Babergh District Council and Mid Suffolk District Council (20041302)

Deadline 6 submission for Bramford to Twinstead (EN020002)

TITLE  
 2.11.7 DESIGN AND LAYOUT PLANS: STOUR VALLEY EAST CABLE SEALING END COMPOUND

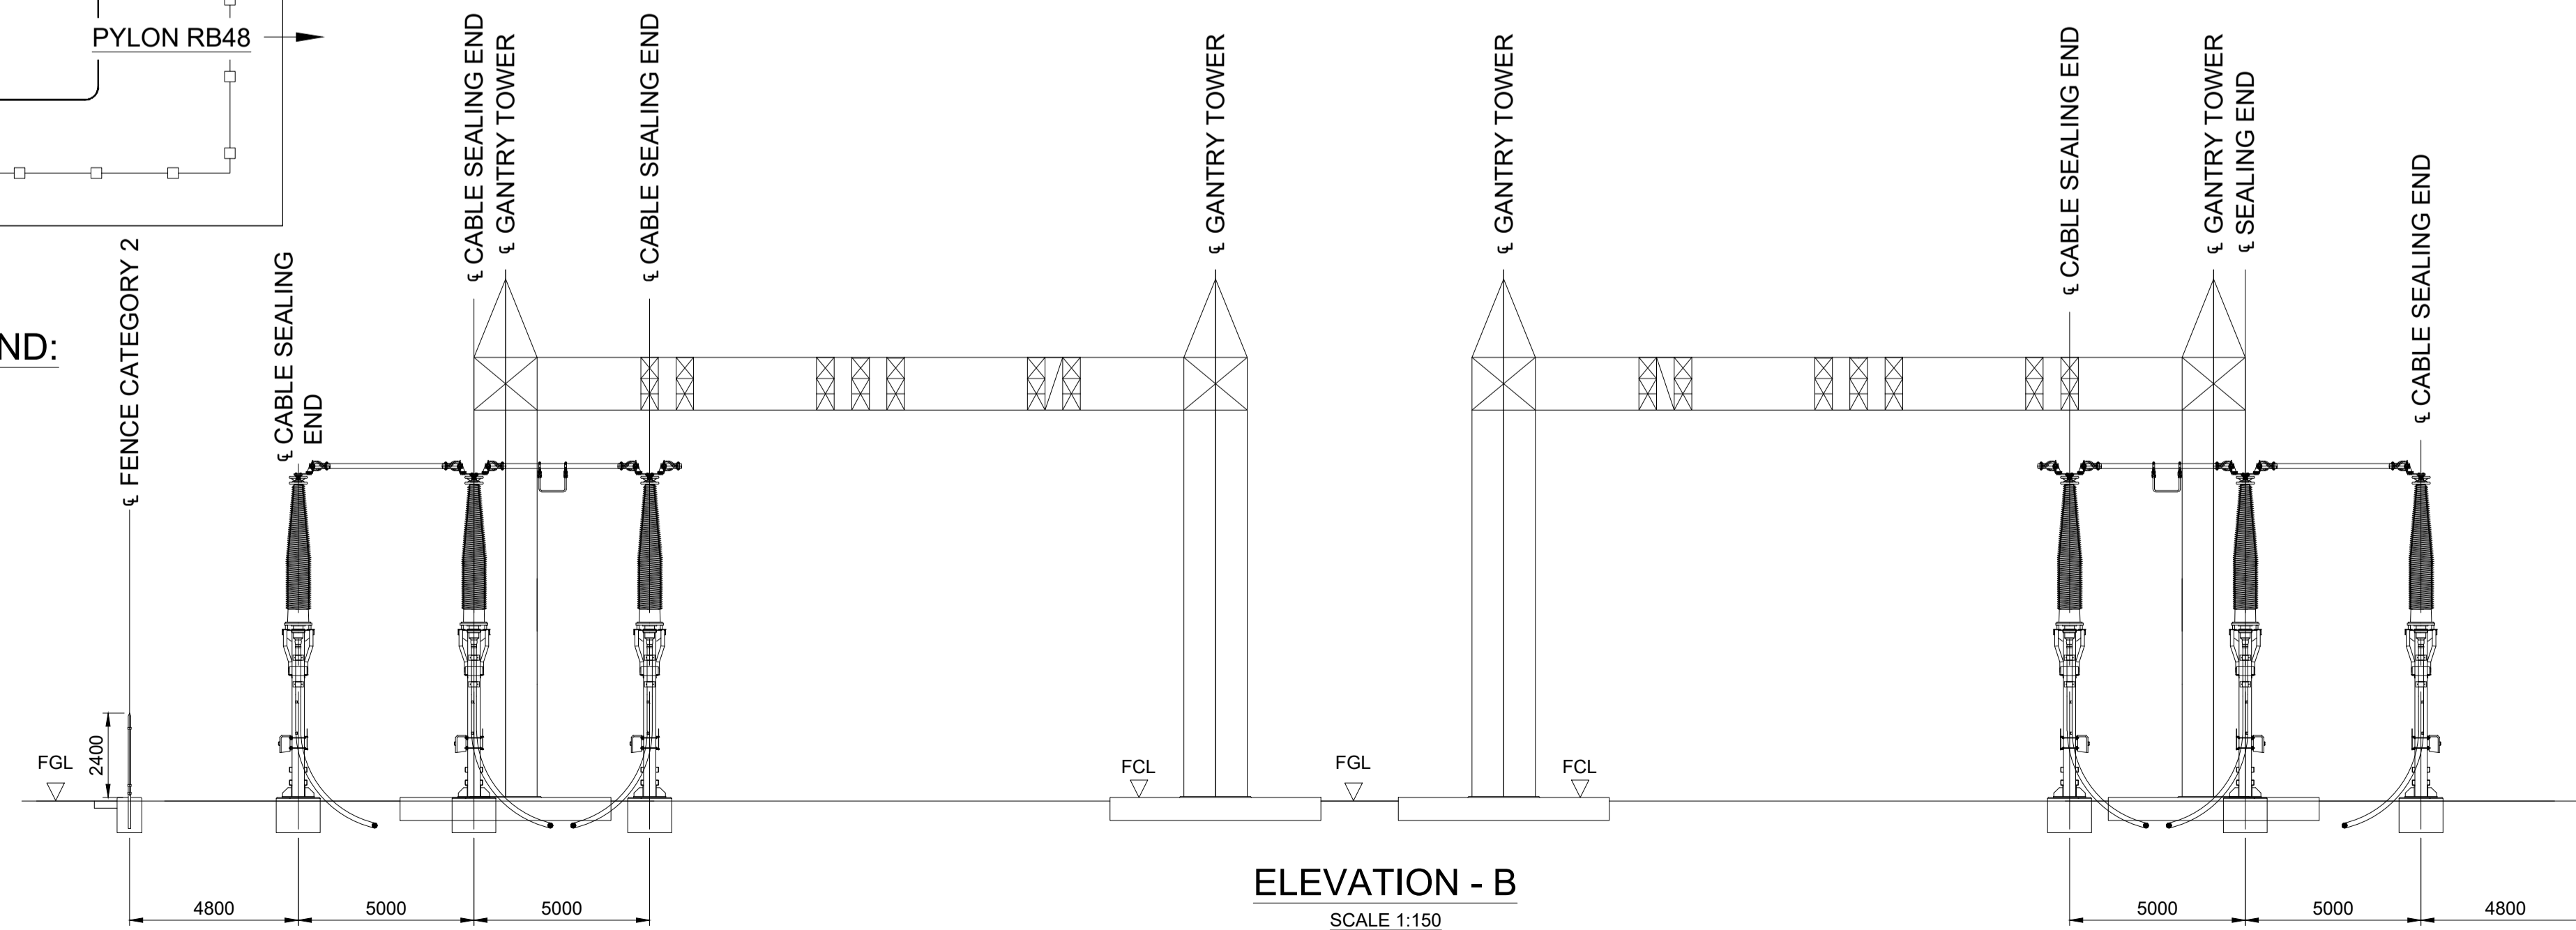
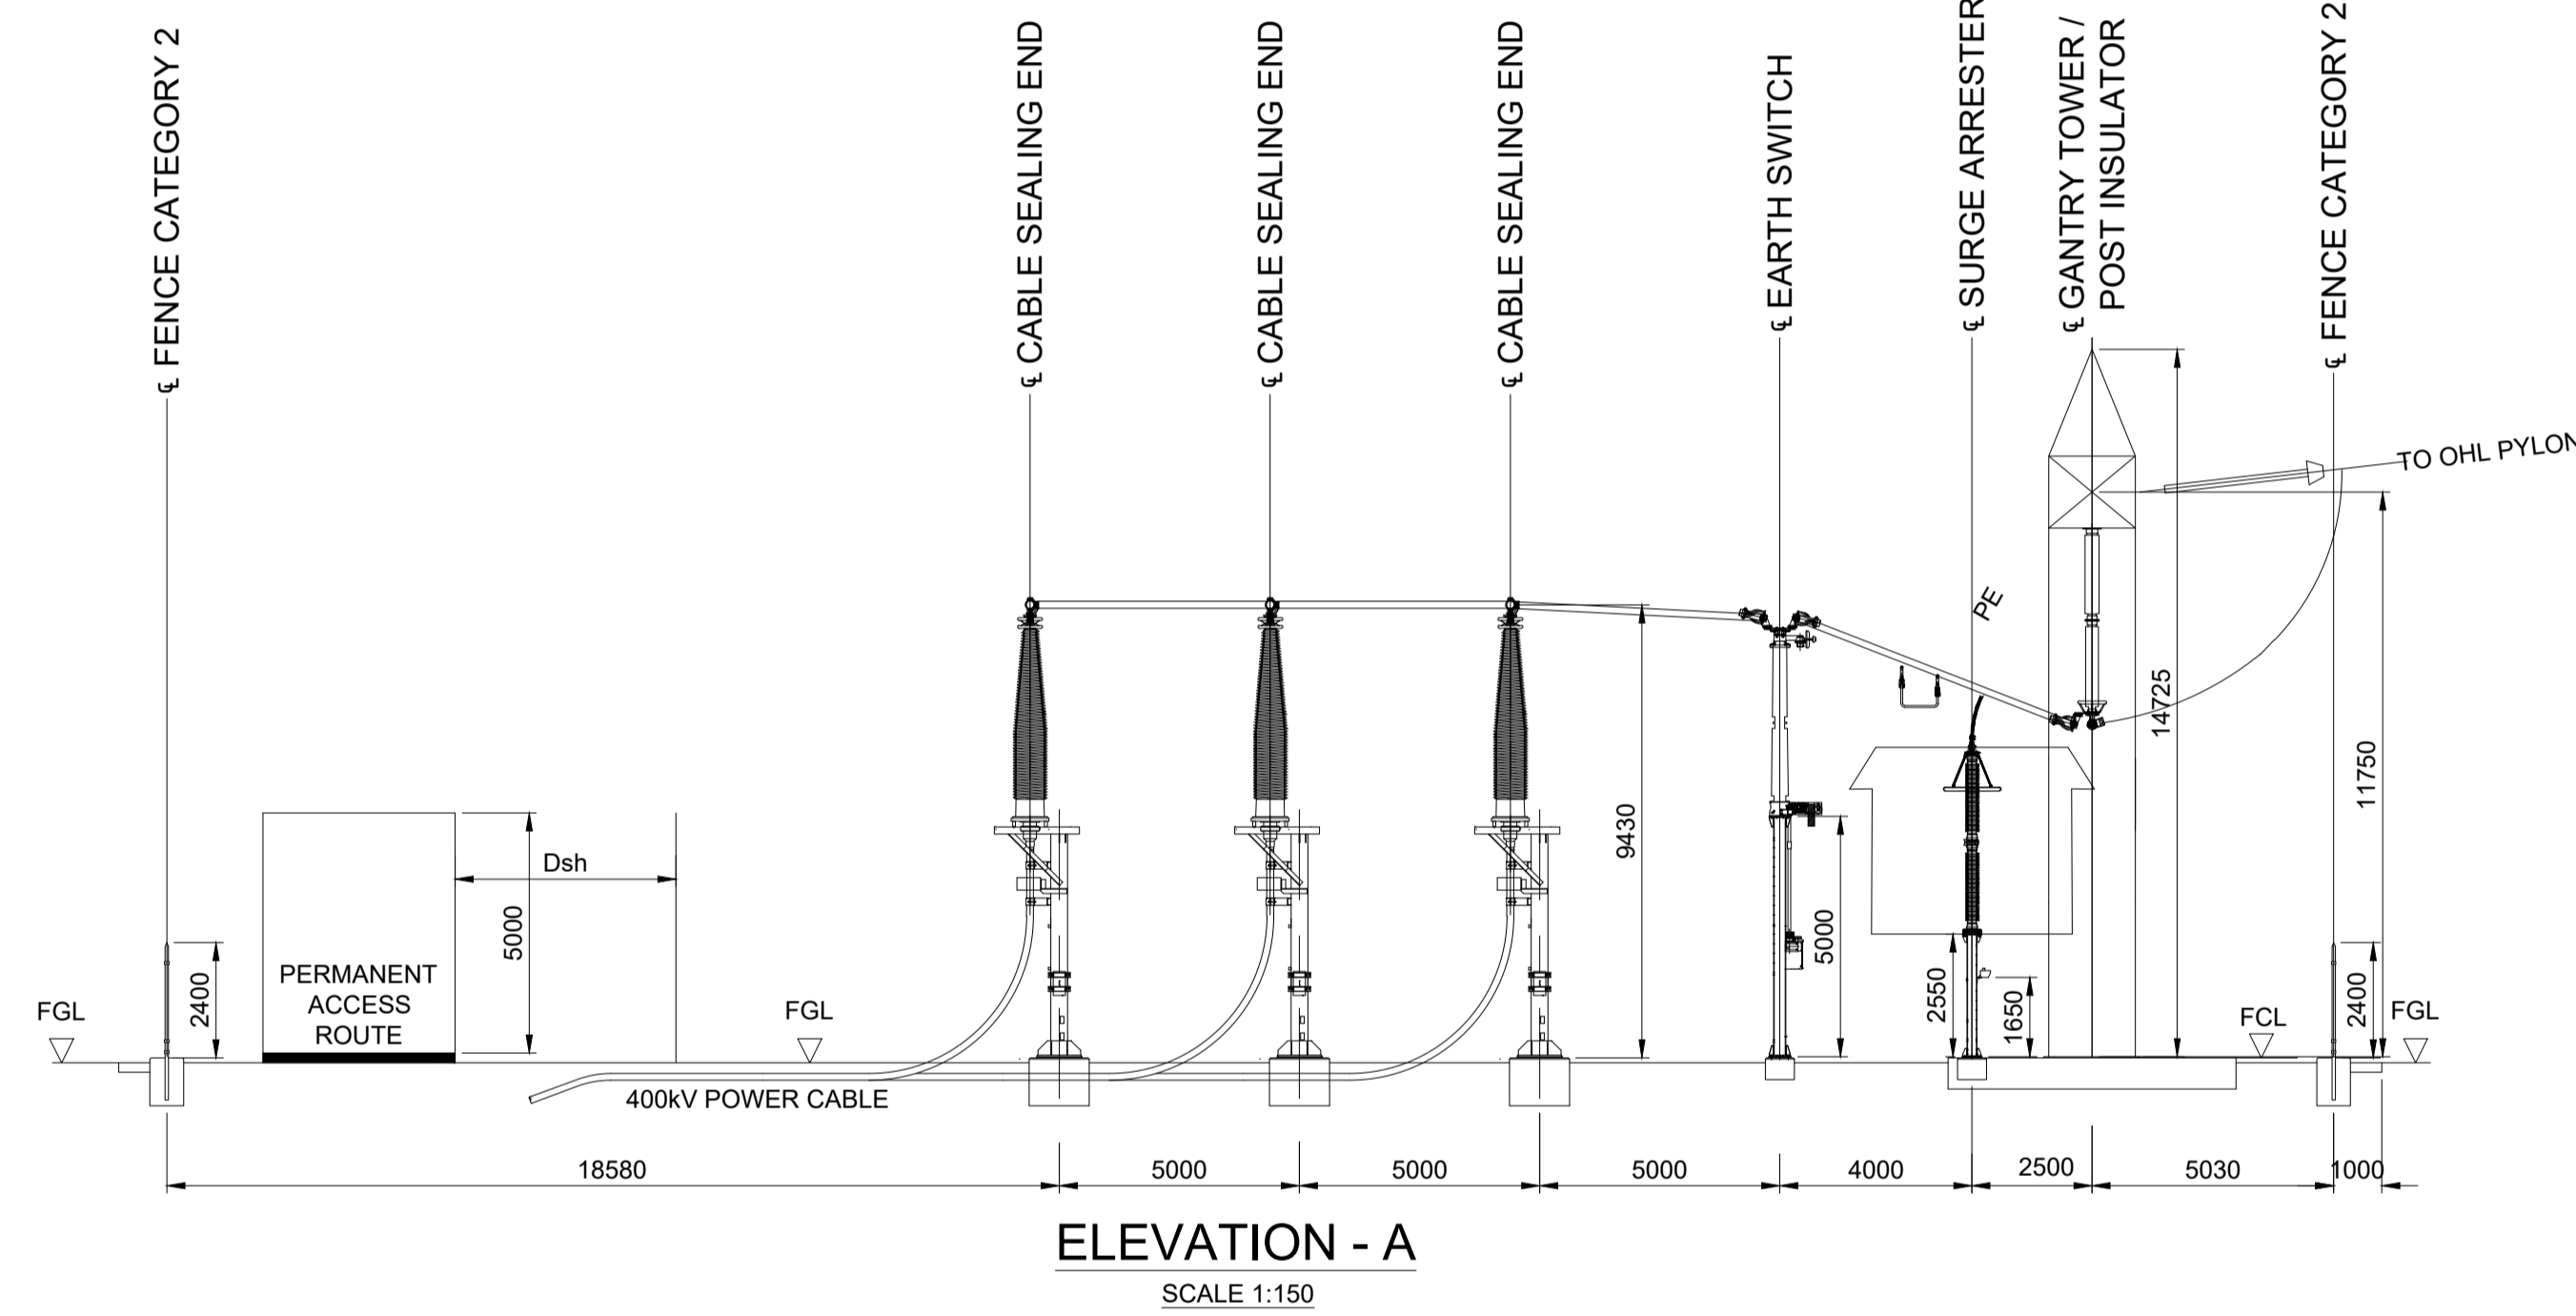
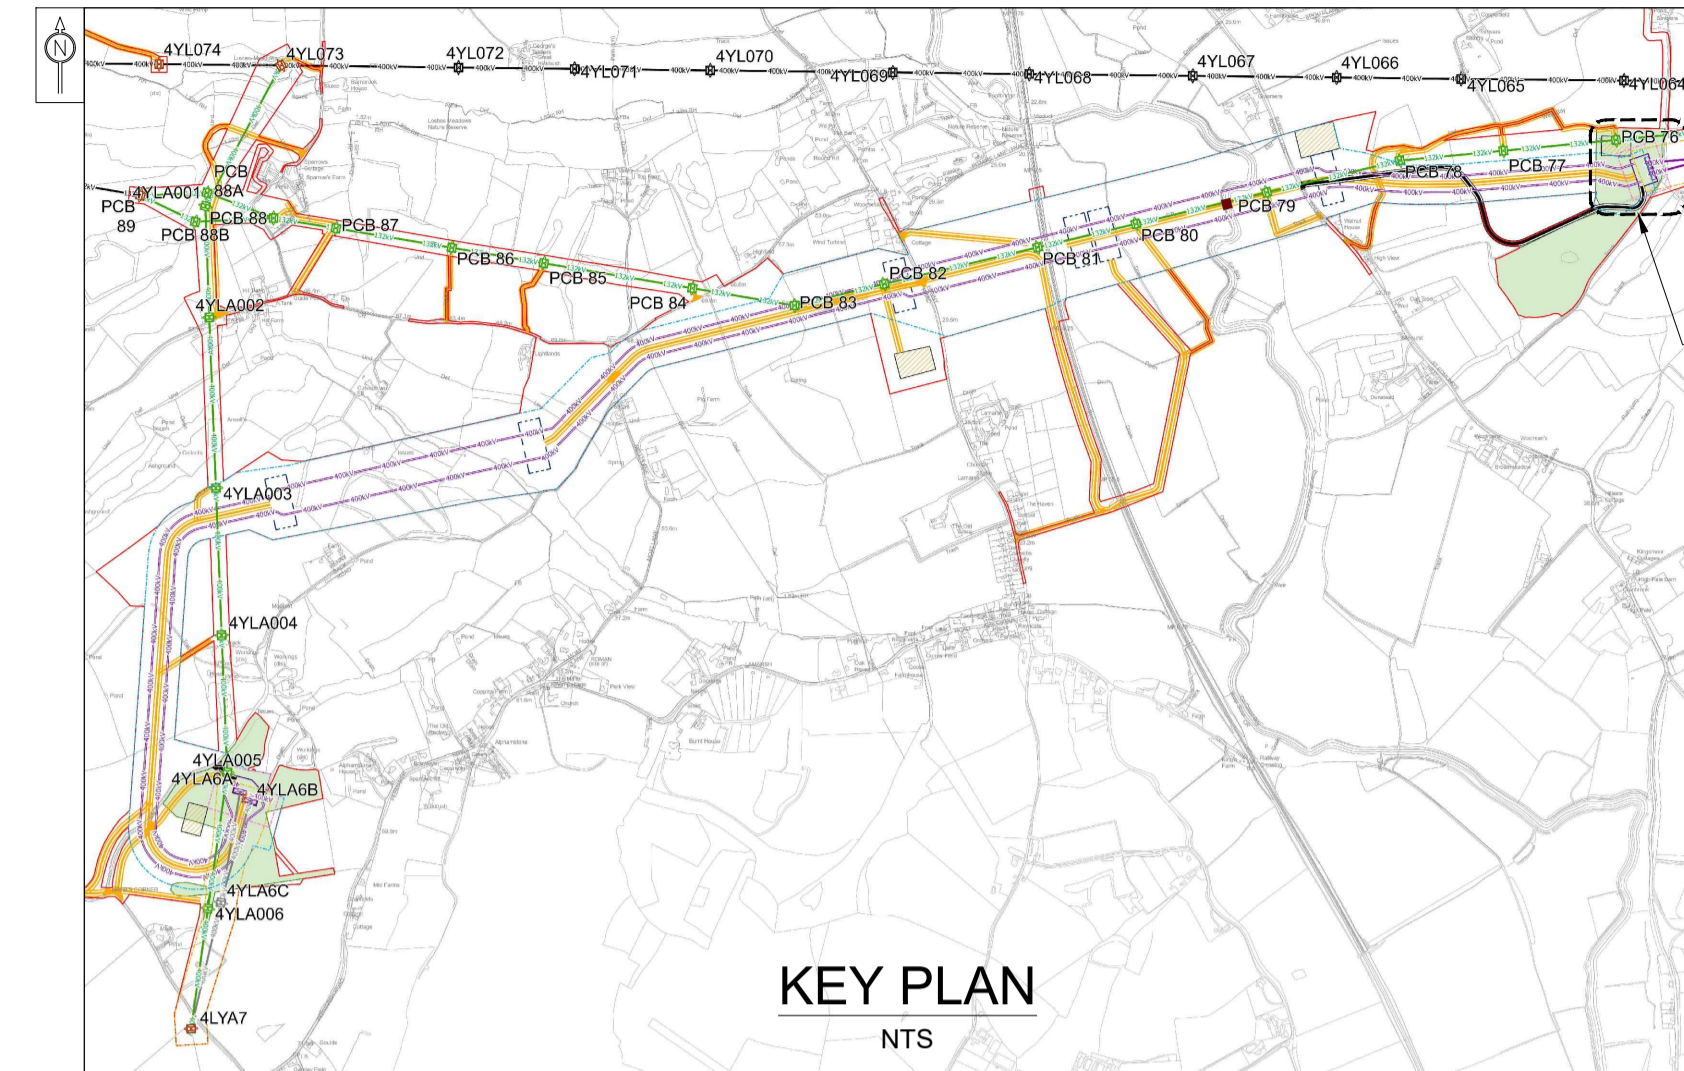
Re 3.5 Visual mitigation planting at the CSE compounds - Stour Valley East The applicant identifies in 3.4 that *'Users of a short section of W-171/001/0 near Sawyer's Farm may have views of the top of the gantries which would be some 300m distant. The adverse effects on these views would however be outweighed by the beneficial effects of removing the existing 132kV overhead line which is seen in much closer proximity as it overflies the footpath.'* A photomontage from the section of PRoW near Sawyer's Farm would help illustrate this claim.
